From: Obafemi Okusipe
Sent: 22 April 2022 10:10
To: Planning.Responses
Subject: FW: LU/411/21/PL - 90-91 South Terrace, Littlehampton
Attachments: Graham Nicholls Flood Risk Assessment.pdf; Flood Risk Assessment.pdf; 28118-PD210B Proposed Elevations and Sections.pdf; ea86700b69424fe.rtf

Further to our telephone conversation, please find attached the Flood Risk Assessment that was submitted and the Original Flood risk Assessment (Graham Nicholls FRA) from the previously approved scheme which has the data from the Environment Agency which states that no habitable accommodation should be provided below 4.95AOD tidal level shown in the 1:200 year event situation.

There is no residential accommodation to the lower ground floor of the proposed scheme and all habitable accommodation is on the upper ground floor and above and the upper ground floor level is set at 5.02AOD (as shown on attached drawing 28118-PD210B).

project Proposed Development 90-91 South Terrace Littlehampton, W Sussex		
detail 1st Floor & 2nd Floor Plans	drawn MAS	checked
date Nov 2021	status Planning	rev C
a1 scale 1:100	a3 scale 1:200

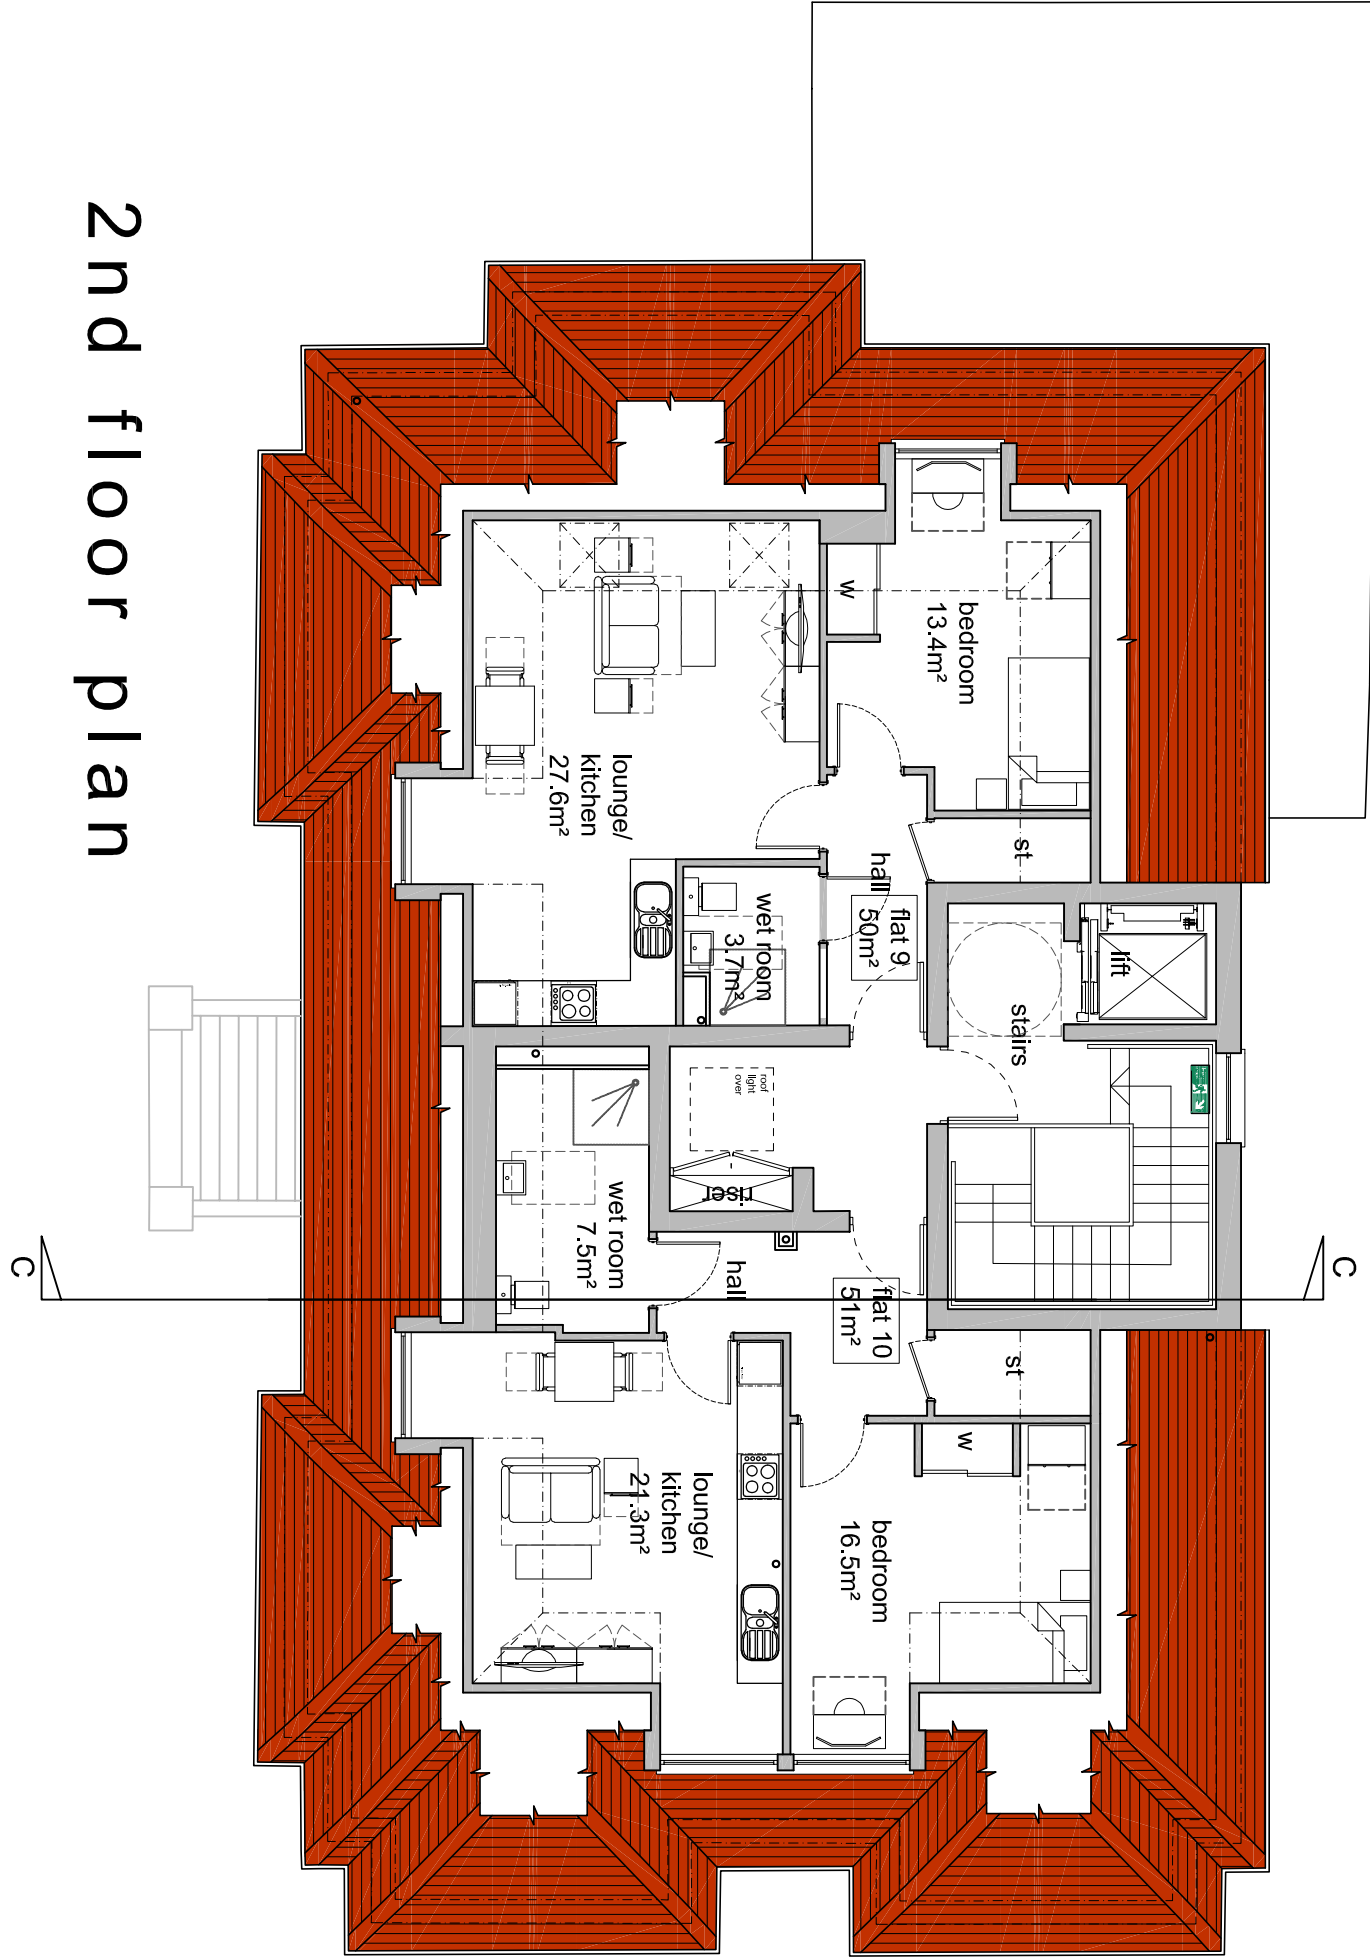
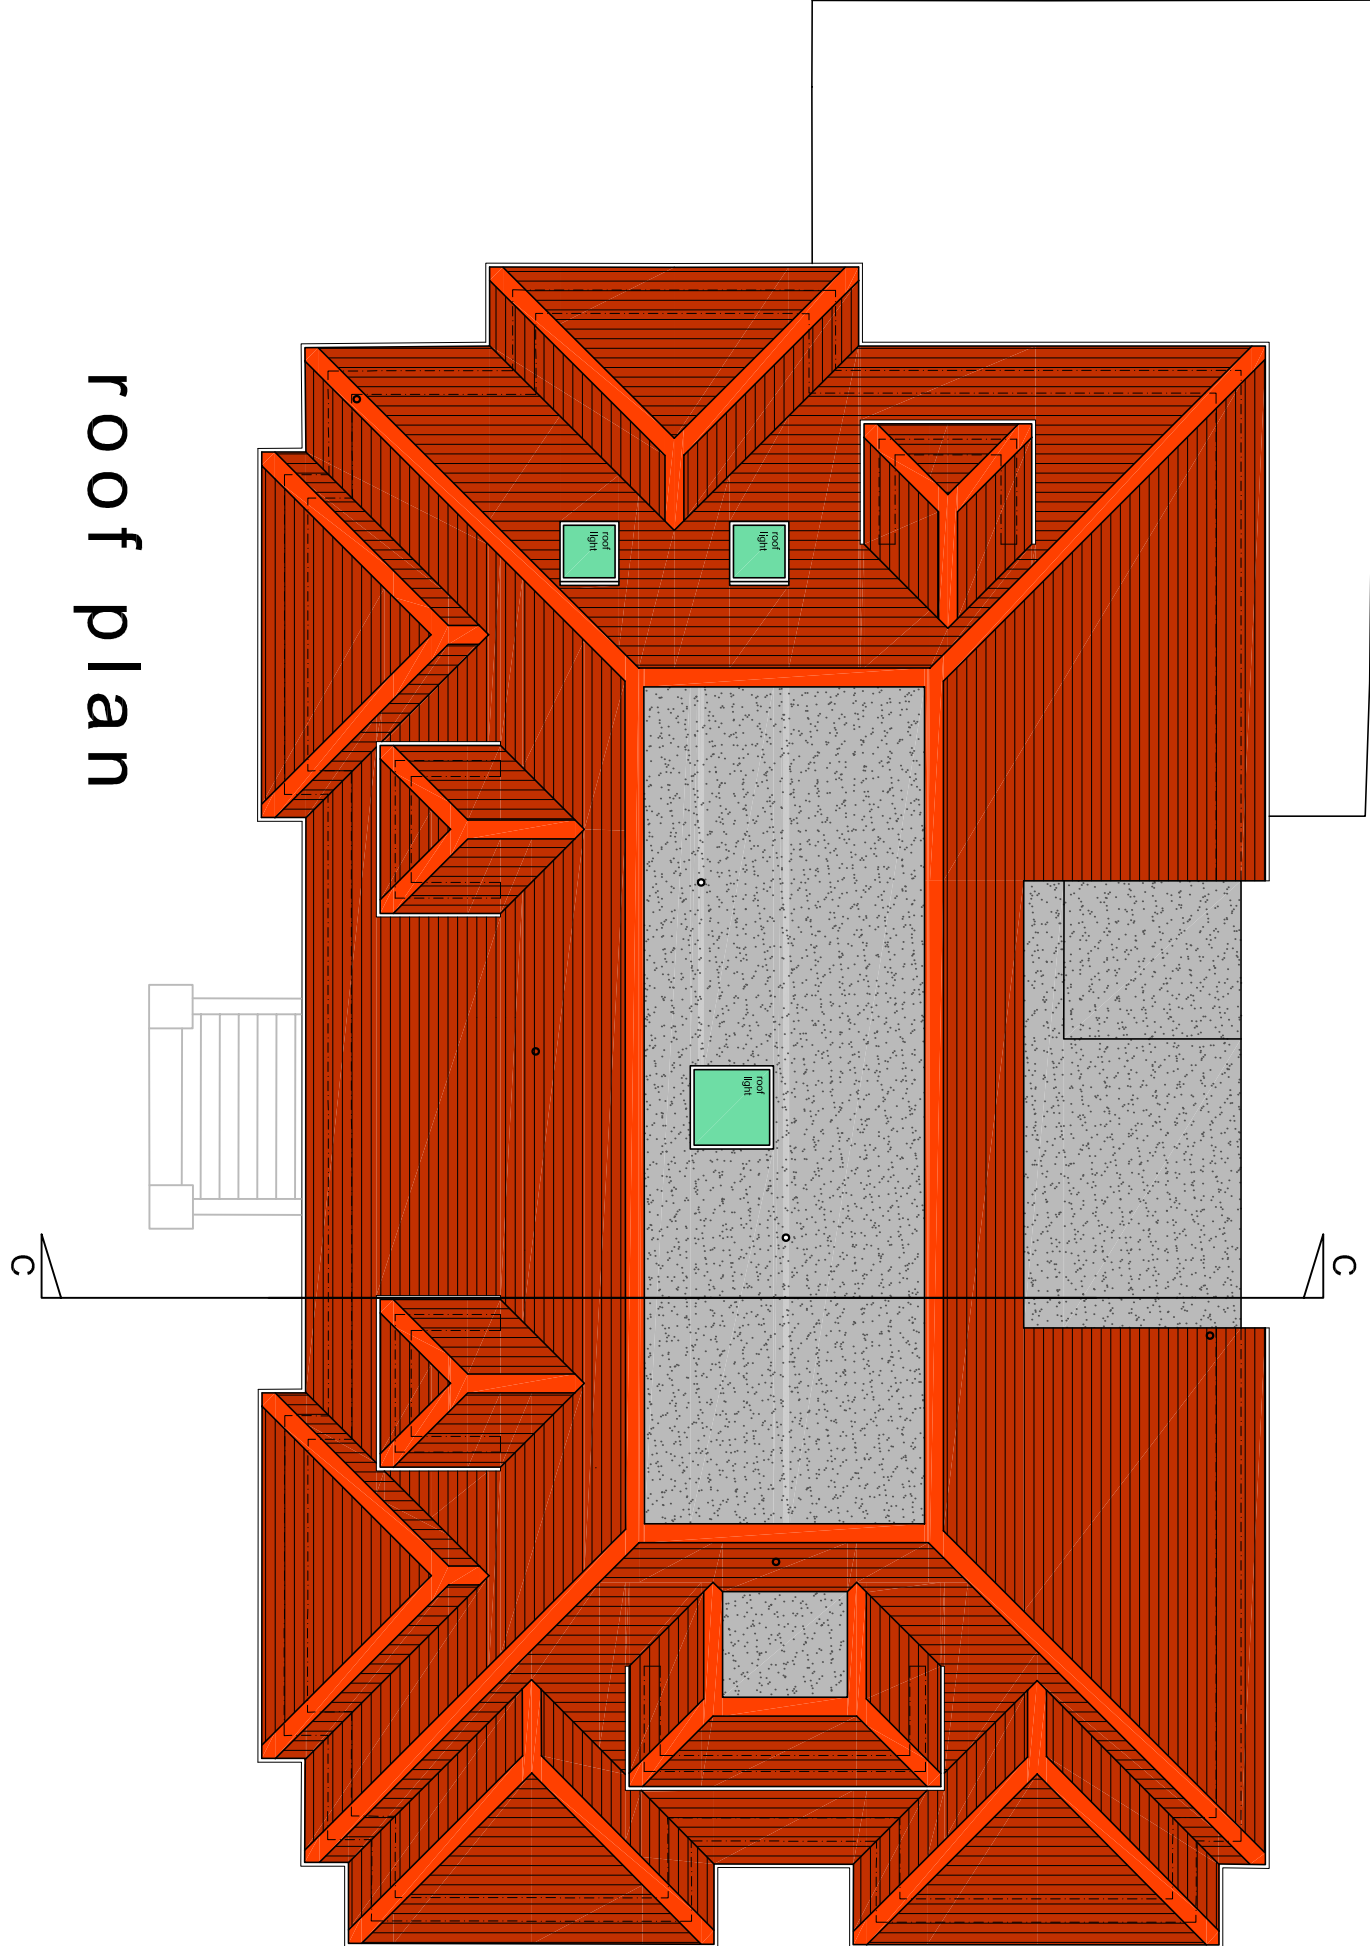
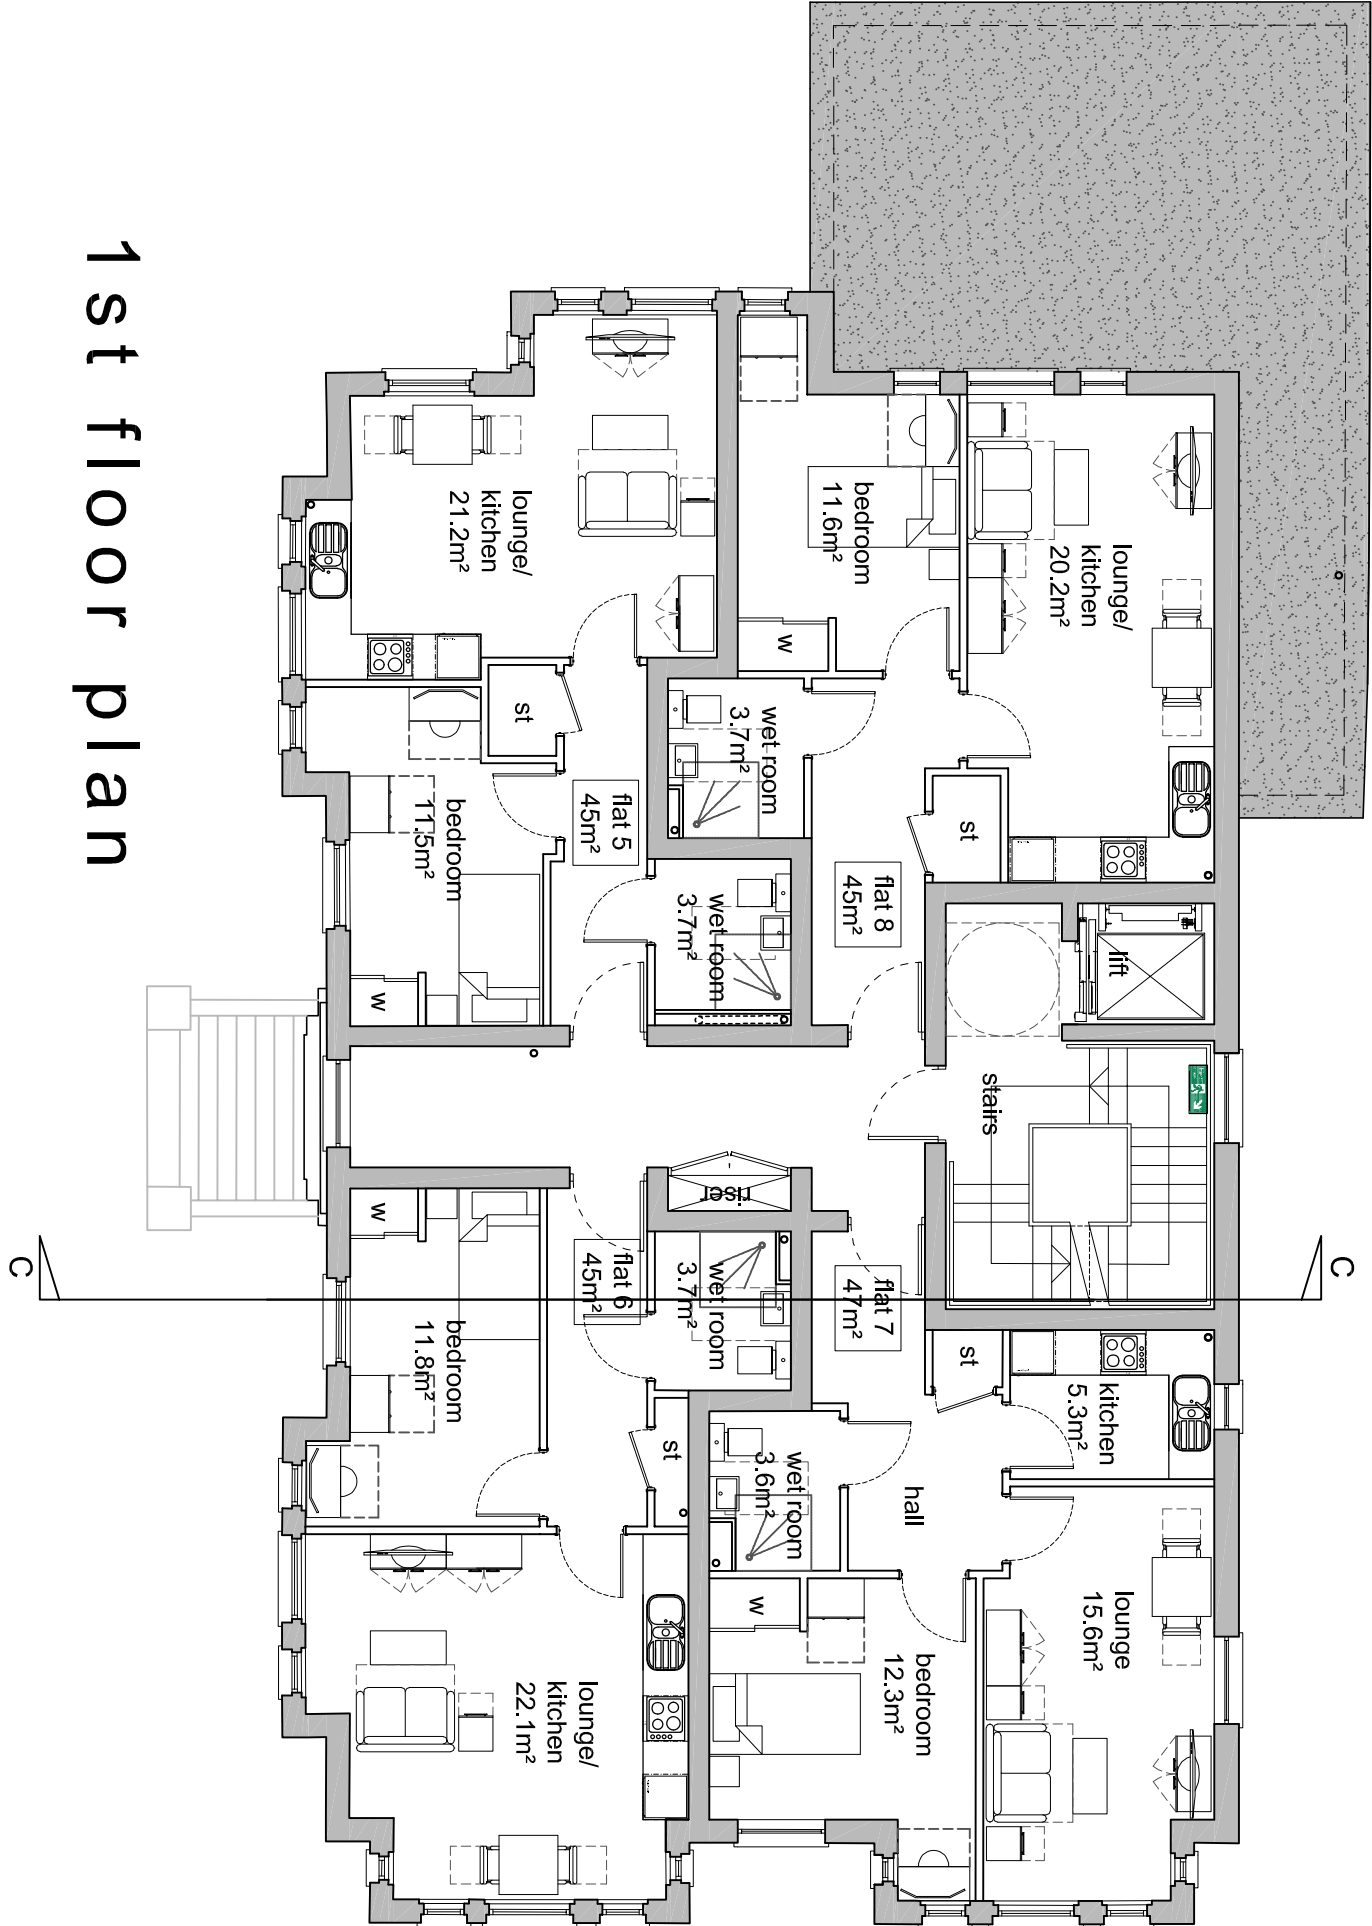
We note your grounds for objection for our proposal, in respect of the materiality proposed.

Render to the first floor (to match that of the neighbouring terrace) was chosen as my client, the contractor felt it would difficult to match the new brickwork above the existing given the existing is 100 years old and weathered accordingly. We felt the join between old and new could appear obvious and detract from the finished aesthetic and details such as the creasing tile headers over windows would be difficult to recreate using modern construction techniques. Use of a sand/ rough render finish at this storey height would match with the same storey finish on the terrace to the east of the proposal, so is not out of keeping with the adjacent street scene

Another reason for utilising render on this new additional storey is the construction to the new upper floors is to be lightweight construction to assist in reducing load on the existing structure, a render finish would enable a lightweight supporting structure to reduce weight. The use of a render would acknowledge the fact this is an evolution of the building. The render would only be to the 1st floor so would be at the same storey as the render on the 1st floor of the adjacent terrace (see photo below).

The use of slate roofing was proposed to lessen the loadings on the structure but, I'm inclined to agree with your comments that this perhaps a departure too far from the adjacent material finish, and so the reinstatement of a clay tile finish may be more appropriate and would better justify the brick lower storey, render upper storey, clay tile roof scape that can be seen on the neighbouring terrace.

All amendments requested by the conservation officer have been made to the elevations (brick to 1st floor and clay tile roof) as per the revised drawings submitted on 22nd March 2022, so these amendments should address the concerns raised.

However having discussed this matter with my client, who is keen for this project to progress, I attach drawings which show the render omitted and full height brickwork shown as per the previously approved plans and in accordance with the conservation officers requirements.

Also shown are clay roof tiles, again in accordance with the approved plans and conservation officers comments.
